CITY OF ALBUQUERQUE

July 20, 2022

**RE: Apple Canyon Gourmet
Temporary C.O. - Accepted
Engineer's Certification Date: 07/26/22
Engineer's Stamp Date: 09/07/21
Hydrology File: D16D002H**

RE: Apple Canyon Gourmet (D16D002H)
Request for Temporary Certificate of Occupancy

GRADING AND  
DRAINAGE PLAN

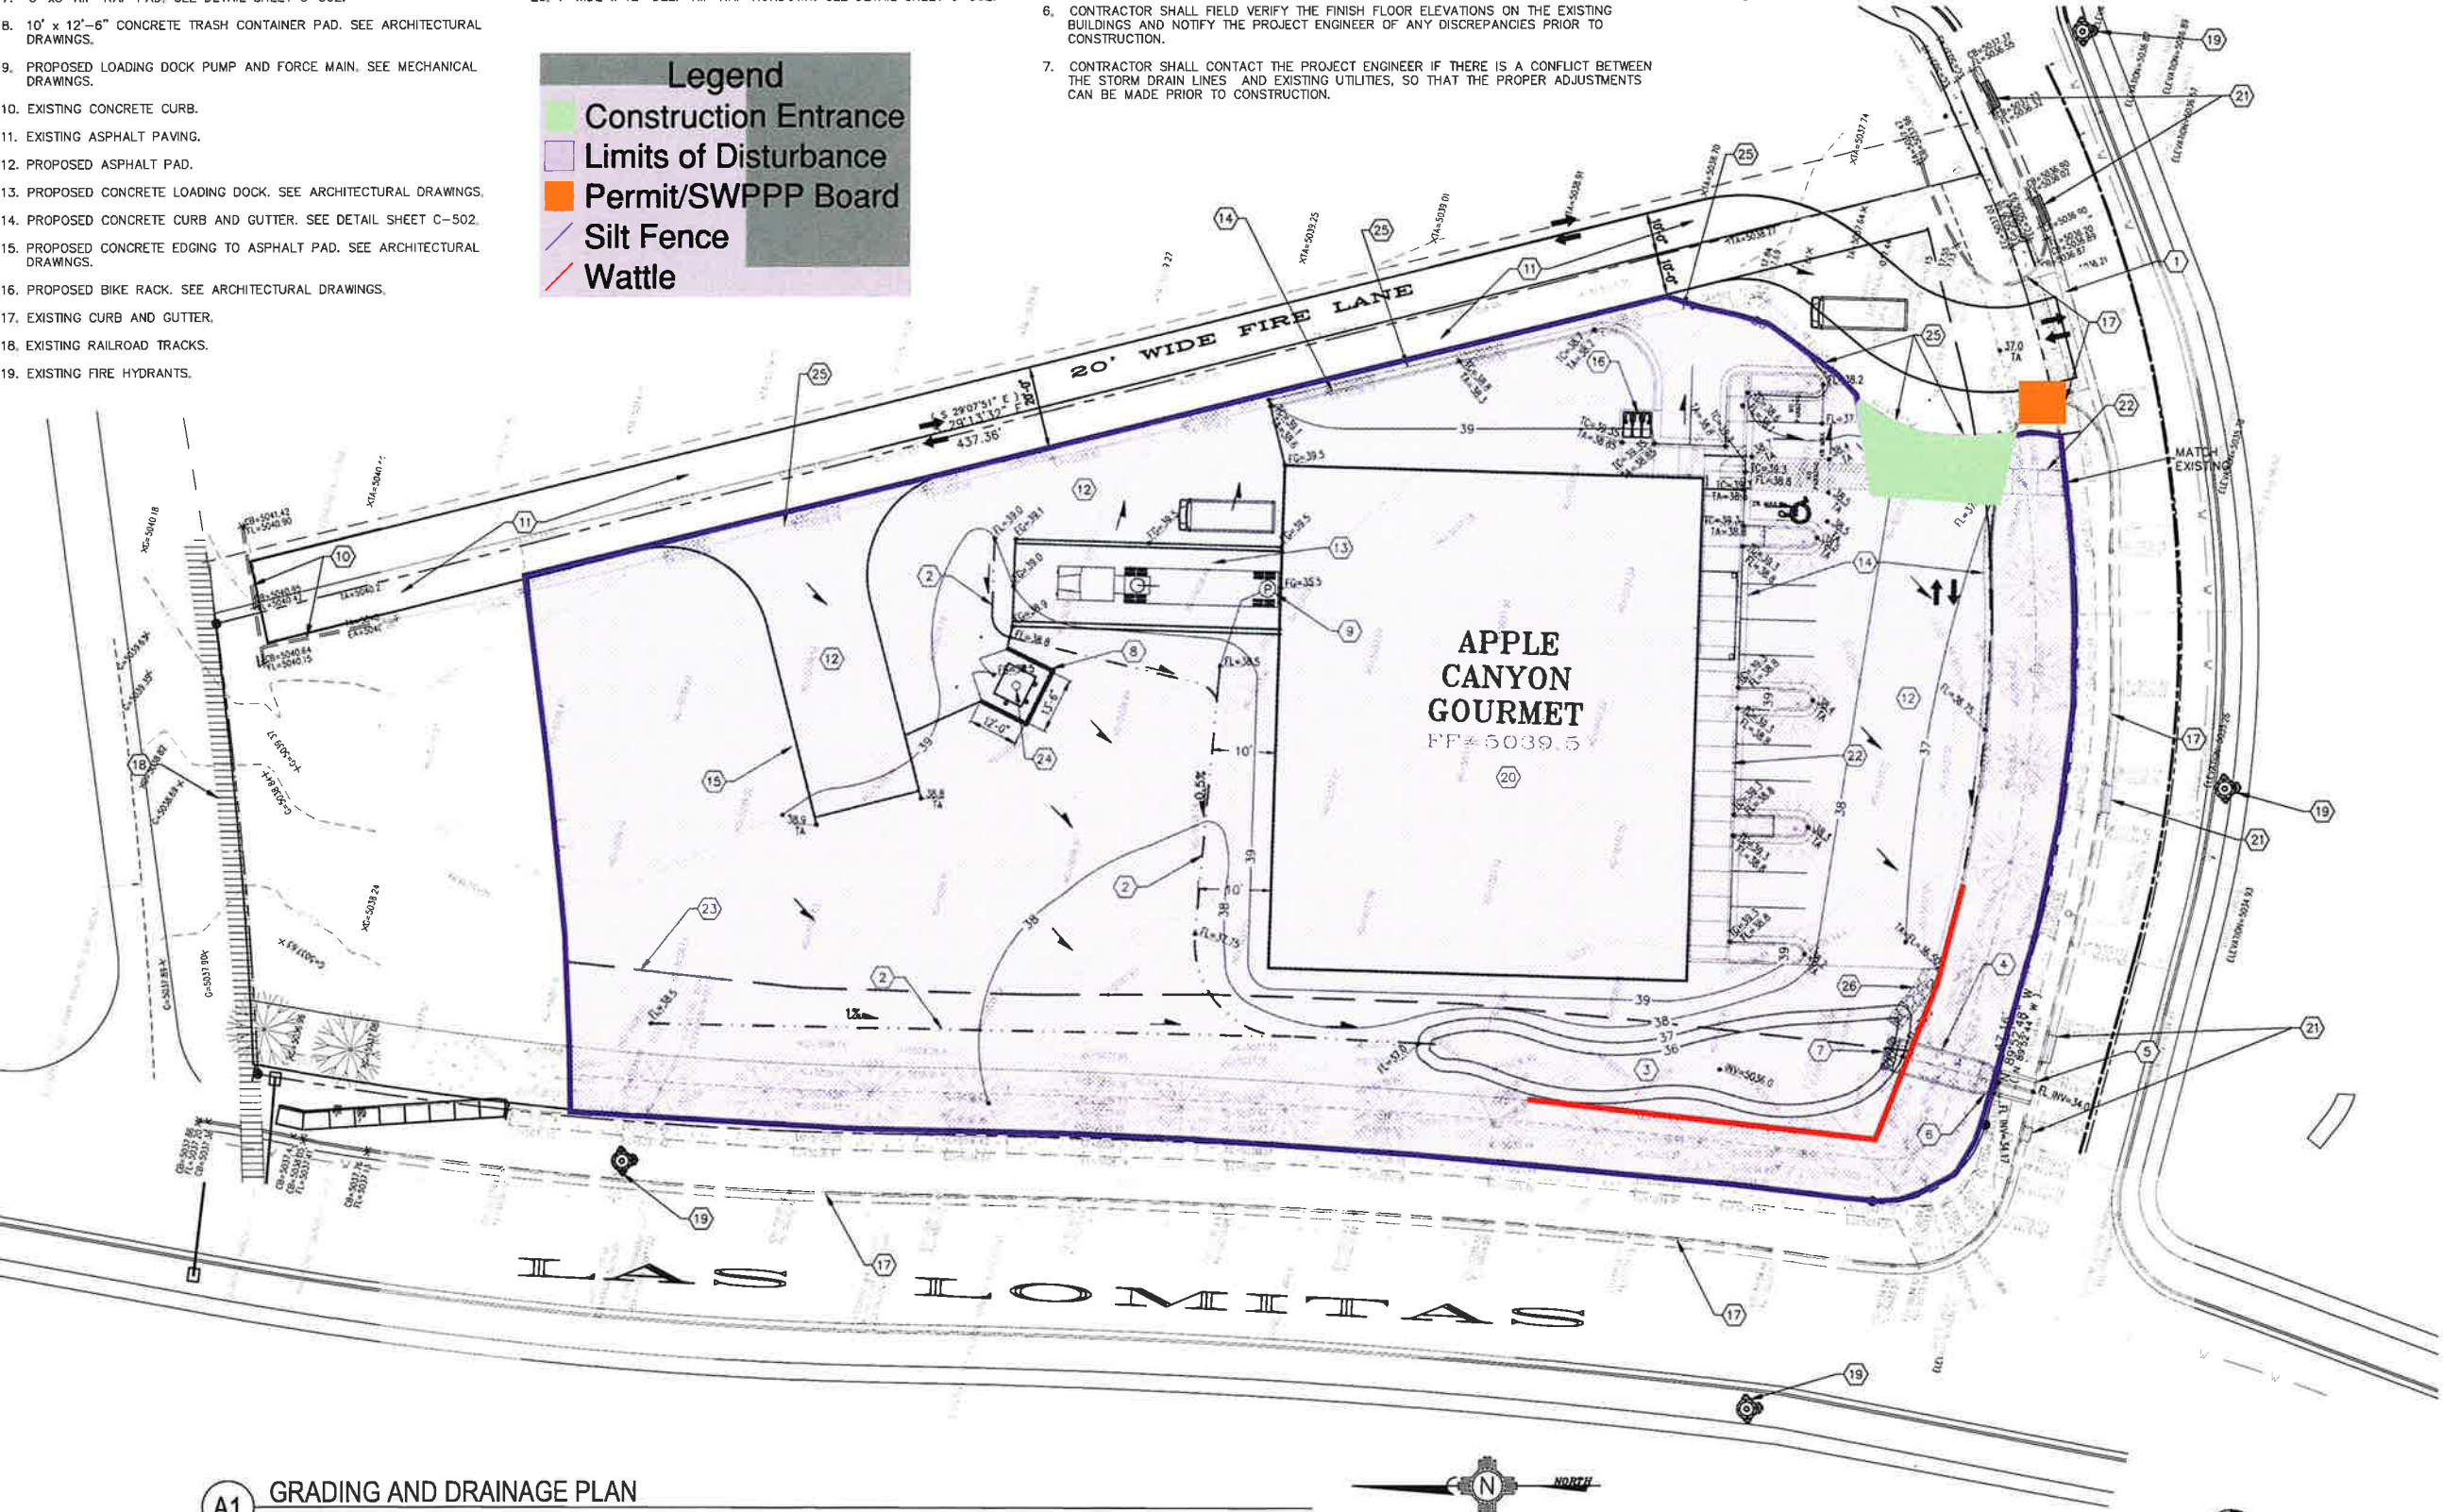
We conducted a site visit today and it appears the project is substantially complete. However, there are several site plan changes and drainage deficiencies that we observed. These issues will need to be resolved prior to preparation of the drainage certification and request for final certificate of occupancy. Some of these issues include the following:

- 1) Site plan changes on the northern portion of the site including the loading dock, trash enclosure and access driveway to the loading dock area.
- 2) The drainage swale located on the north and west portions of the site need to be better defined.
- 3) The northern roof drains need to be raised and splash blocks placed under them to promote positive drainage away from the foundation system of the building.
- 4) The rip rap run down into the drainage pond needs to be extended to the invert of the pond and will need to be reshaped to a V-shape.
- 5) There may be a small ponding issue on the HMA driveway approach to the loading dock area on the north side near the railroad tracks.

The Permanent CO submittal will contain an as-built survey with the required engineering certification and be submitted once the information is received by our office and the above items have been satisfactorily addressed.
